**From:** John Flanigan <John.Flanigan@randwick.nsw.gov.au>  
**Sent:** Wednesday, 9 June 2021 3:47 PM  
**To:** Mitch Ryan  
**Cc:** Candice Pon; Edan Norris - Accord; Habib Omaree; Brigitte Bradley  
**Subject:** FW: 4 - 18 Doncaster Ave - Student Accommodation - OSD Modification  
**Attachments:** 360\_Kensington\_Design Statement - Trees near OSD 210521.pdf

**From:** Mitch Ryan <mryan@nextgrp.com.au>  
**Sent:** Tuesday, 25 May 2021 10:41 AM  
**To:** John Flanigan <John.Flanigan@randwick.nsw.gov.au>  
**Cc:** Candice Pon <Candice.Pon@planning.nsw.gov.au>; Edan Norris - Accord <enorris@accord.property>; Habib Omaree <homaree@nextgrp.com.au>; Brigitte Bradley <bbradley@urbis.com.au>  
**Subject:** RE: 4 - 18 Doncaster Ave - Student Accommodation - OSD Modification

**From:** Mitch Ryan  
**Sent:** Thursday, 20 May 2021 3:34 PM  
**To:** John Flanigan <[John.Flanigan@randwick.nsw.gov.au](mailto:John.Flanigan@randwick.nsw.gov.au)>  
**Cc:** Candice Pon <[Candice.Pon@planning.nsw.gov.au](mailto:Candice.Pon@planning.nsw.gov.au)>; Edan Norris - Accord <[enorris@accord.property](mailto:enorris@accord.property)>; Habib Omaree <[homaree@nextgrp.com.au](mailto:homaree@nextgrp.com.au)>

**Figure 5 | Extract of Proposed Landscaping – lawn area raised to generally align with surrounding levels (Base source: Applicant's RtS)**

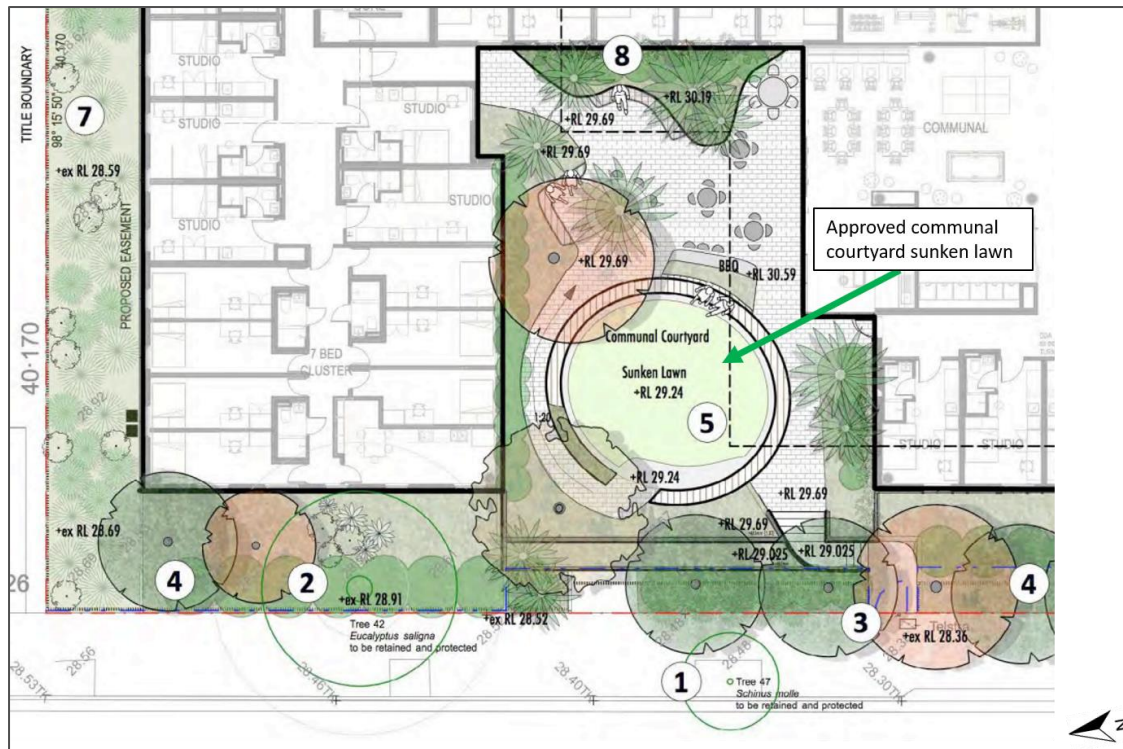
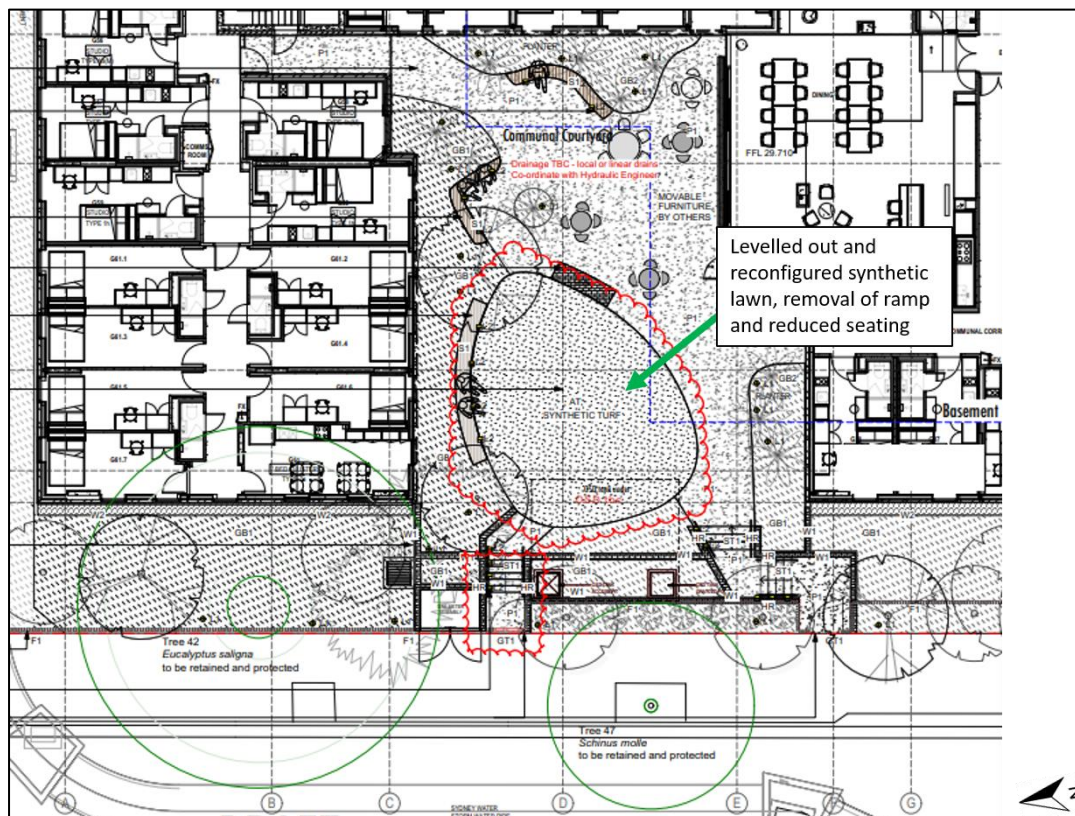
1. Document L-1001 – Landscape architect has confirmed the trees in front of the OSD tank (highlighted in the blue rectangle) is in the lower planter box and has enough soil depth and space for adequate growth. Please also note a few changes on the attached, and below snippets of DA vs current:
  - a. Additional staircase introduced for fire egress compliance
  - b. Sunken lawn raised to be one level and changed to astro turf. This makes the space more usable for the students and astro turf reduces risk of grass growth issues of soil coverage with OSD tank below as well as maintenance with high student use.

2. Document L-1002 – Behind the communal area the space has been levelled out and stairs shifted to the left. This allows for greater space for students to use and potential for gym classes to flow from the internal to use the external space. No affect on planting.

This matter has been considered by Council's Landscape Development Officer (David Meredith) who raises no issues with the proposed amendments as shown on the attached plans and below.

David has formed the view that the variations are relatively minor and essentially just involve a reconfiguration of what was originally proposed.

The intent of the design will still be maintained.
